Attachment M – Detailed Response to Submissions Table

Attachment M – The Children’s Hospital at Westmead – Paediatric Services Building (SSD- 10349252) – Detailed Response to Submissions Table

Figure 1 PSB Construction vehicle routes

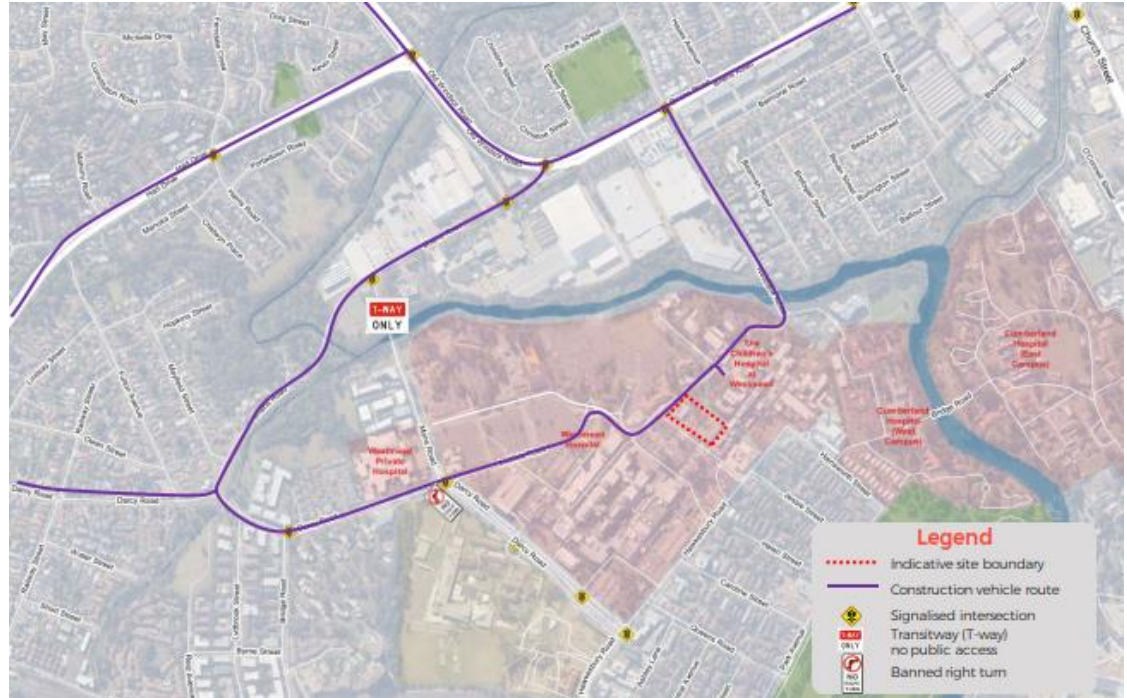
Comment in submission	Applicant's response
		 <p>Figure 6 Classification of wind comfort at 1.5m above local ground level – external terraces/courtyards Source: Arup</p> <p>For further detail, refer to the revised Environmental Wind Assessment Report prepared by Arup at Attachment F.</p>
11	<p>Transport</p> <p><i>The cumulative construction impacts are to be further investigated and assessed, taking into consideration light rail works and concurrent building construction works.</i></p>	<p>It is expected construction of the PSB may coincide with construction of the Parramatta Light Rail (PLR) and Sydney Metro West.</p> <p>While construction vehicles will have origins and destinations from a wide variety of locations, construction vehicles are generally limited to the arterial road network, and dedicated construction vehicle routes are developed with the aim to provide the shortest distances to/from the arterial road network.</p> <p>The primary construction vehicle routes for the PSB are likely to include to/from north and east via Redbank Road and Briens Road and to/from south and west via Institute Road, Darcy Road and Cumberland Highway. Redbank Road would be the preferred route, as it provides a more direct access between the site and the arterial road network to/from the site from the north-east.</p> <p>These routes are shown below in Figure 7 and Figure 8.</p>

Comment in submission	Applicant's response
	 <p>Figure 8 Sydney Metro West construction vehicle route Source: NSW Department of Planning, Industry and Environment</p> <p>It is understood that the primary construction vehicle route for Sydney Metro West and Westmead Metro Station would be Hawkesbury Road and the M4 to the south, and that the primary construction vehicle route for PLR would be Hawkesbury Road, Darcy Road and Cumberland Highway.</p> <p>The preliminary estimated peak construction volumes for the PSB are up to 20 vehicles per hour and up to 100 vehicles per day. Given the low anticipated peak construction activity and the</p>

ATTACHMENT D
LATEST ARCHITECTURAL
PLAN SHOWING DRIVEWAY
AND RAMP GRADIENTS

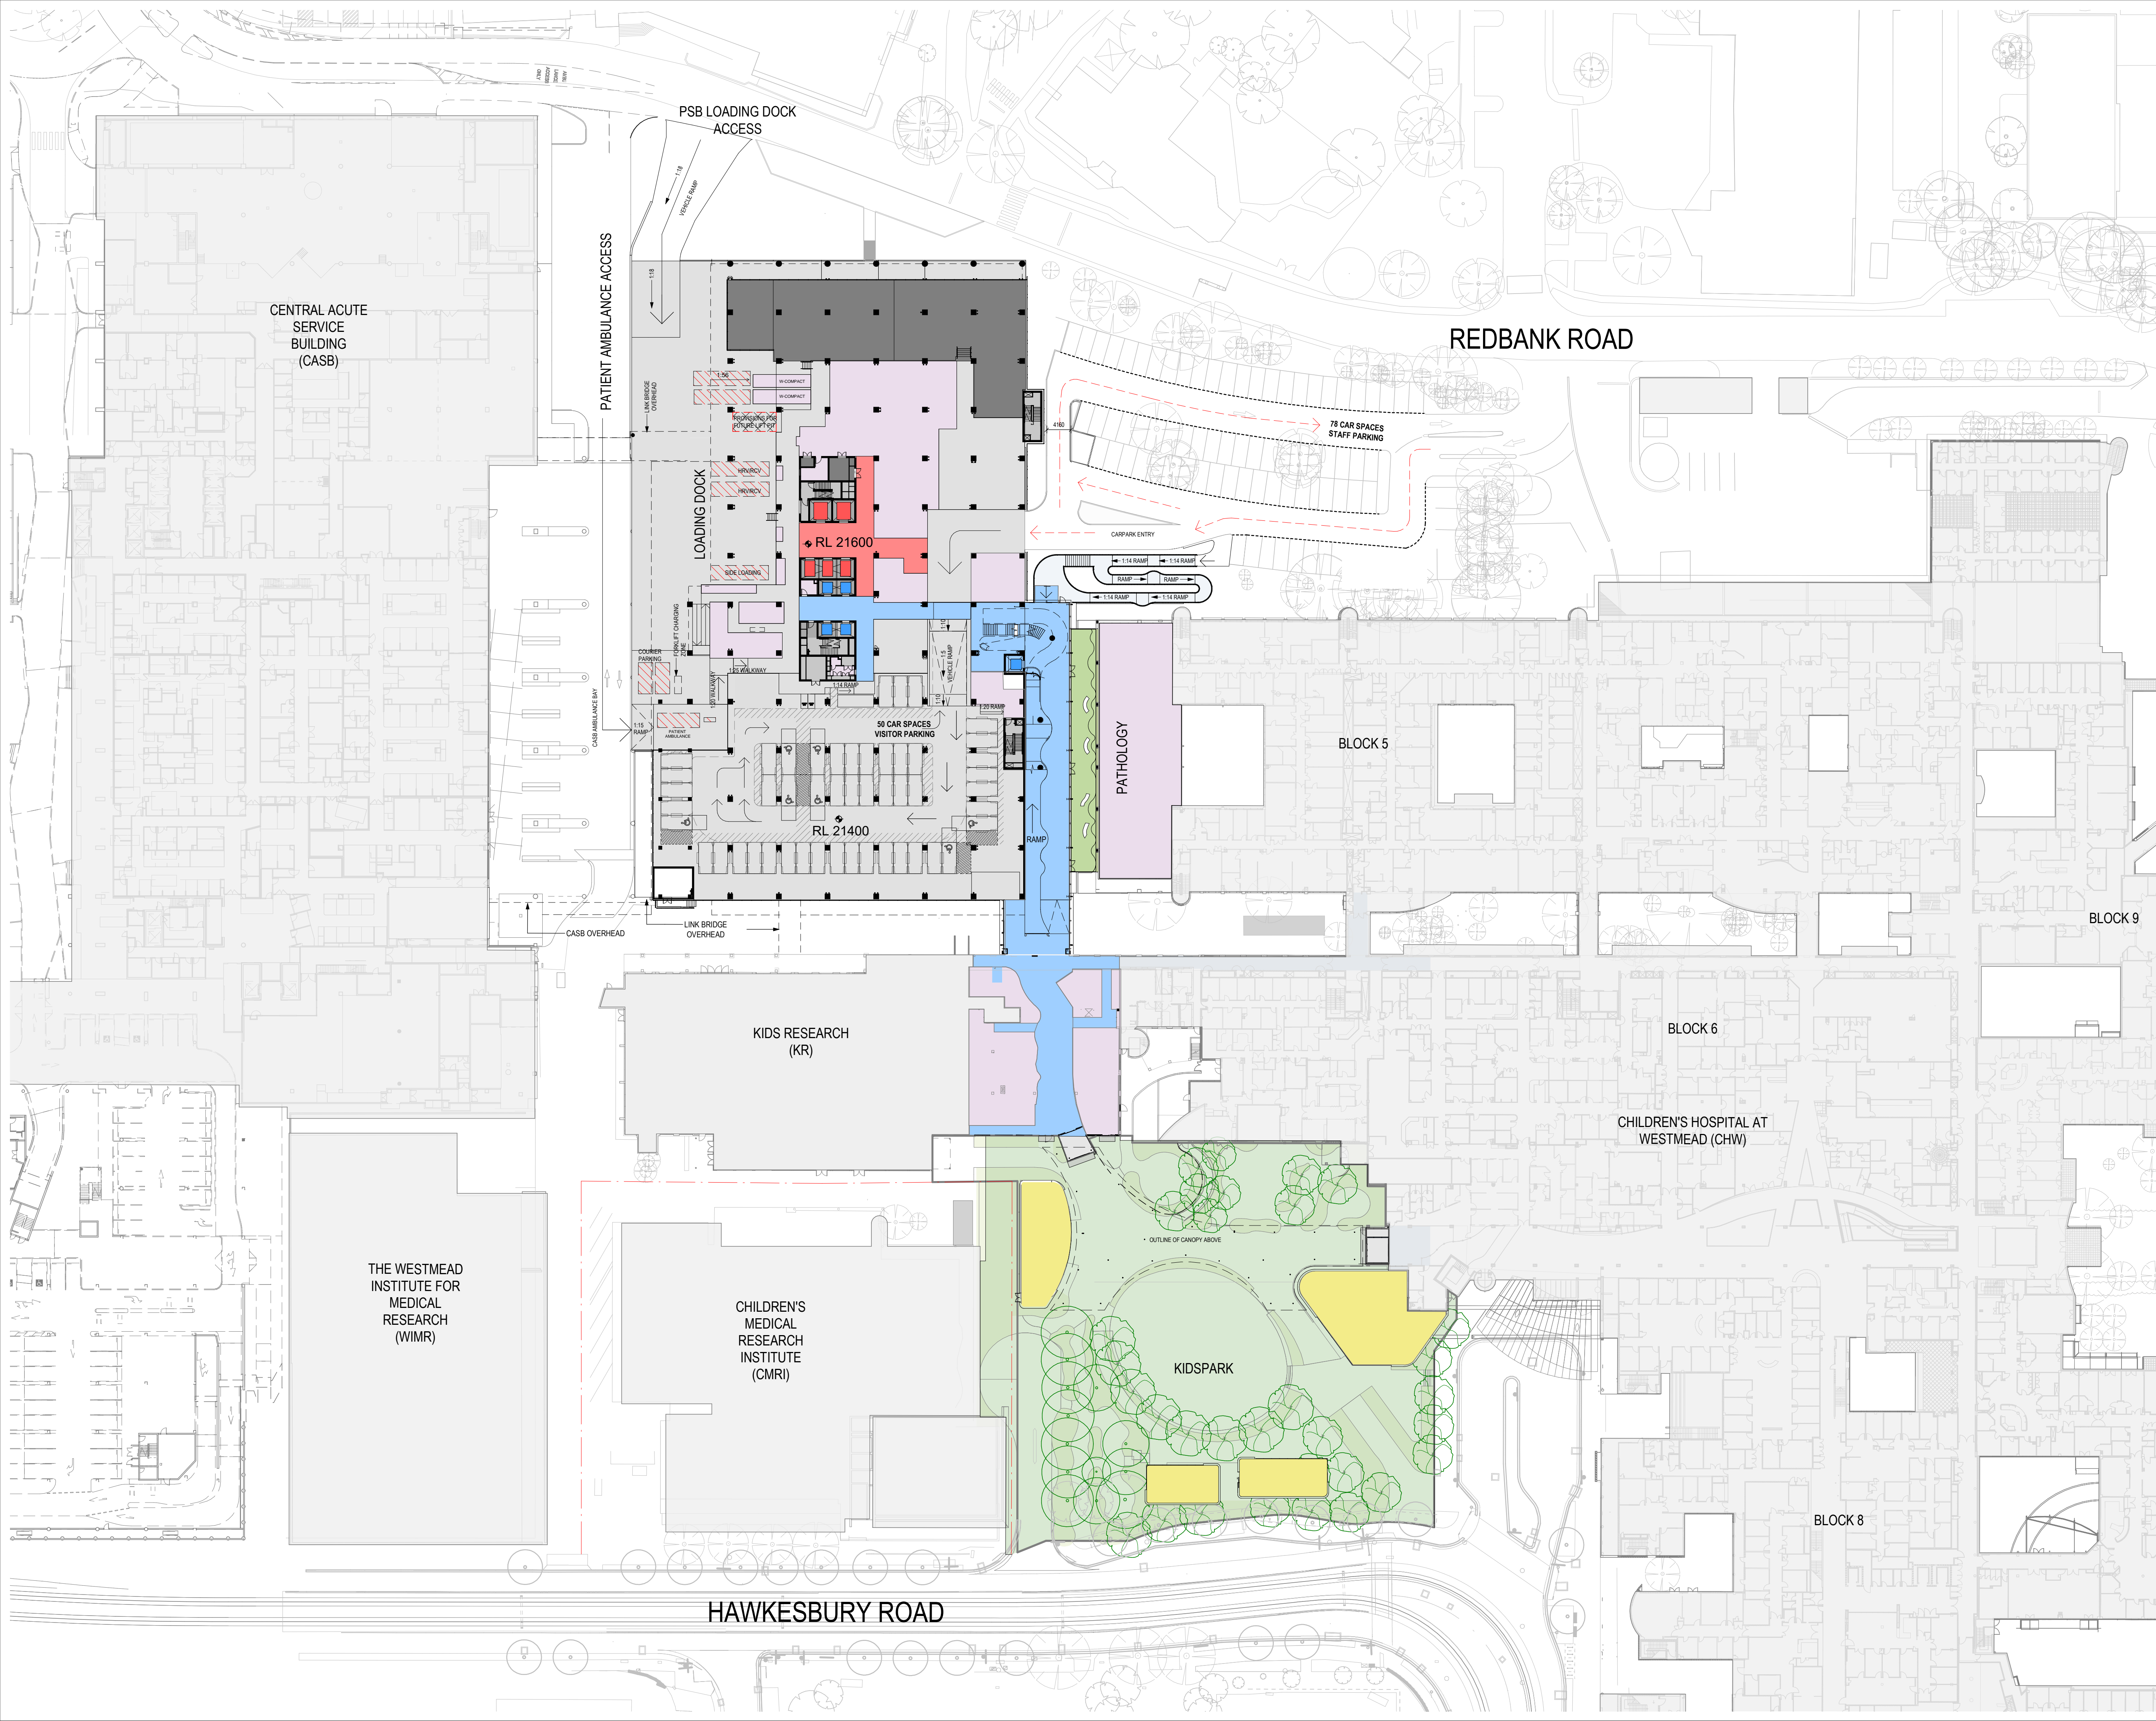
<p>32 Traffic and Transport</p> <p><i>The architectural plans provided indicates that the parking dimensions proposed will be 2.4m wide and 5.4m long. This will need to be amended to comply with the Australian Standards for Class 3 vehicles (i.e., 2.6m wide and 5.4m long).</i></p>	<p>The architectural plans have been amended to reflect that the parking spaces are proposed to be 2.5m wide, complying with Australian Standards for Class 2. The width of the spaces is limited to 2.5m due to the column sizes and standardised grid design required for the clinical nature of the building.</p> <p>In terms of the difference in car parking space 'class':</p> <ul style="list-style-type: none"> – Class 3 is generally defined for short-term parking with the design criteria requiring <u>full opening for all doors</u> and 2.6m wide angled (90 degrees) parking spaces. It is understood that hospital and medical centres were used as examples for Class 3 in AS2890.1. – Class 2 is generally defined for medium-term parking with the design criteria requiring <u>full opening for all doors</u> and 2.5m wide angled (90 degrees) parking spaces. Long-term city and town centre parking were used as examples for Class 2 in AS2890.1. <p>To understand the length of stay at car parks, the boom gate activities for both the former P17 staff car park and P6 visitor car park were monitored as part of the study to understand the ingress/egress patterns for staff and visitors to the hospital – shown in the graphs at Figure 11 and Figure 12. The graph shows that ingress activities are highest in the AM peak and egress activities highest in the PM peak. The lack of activity in between the two peak periods indicates longer stay with minimal short stay high turnover demand.</p>
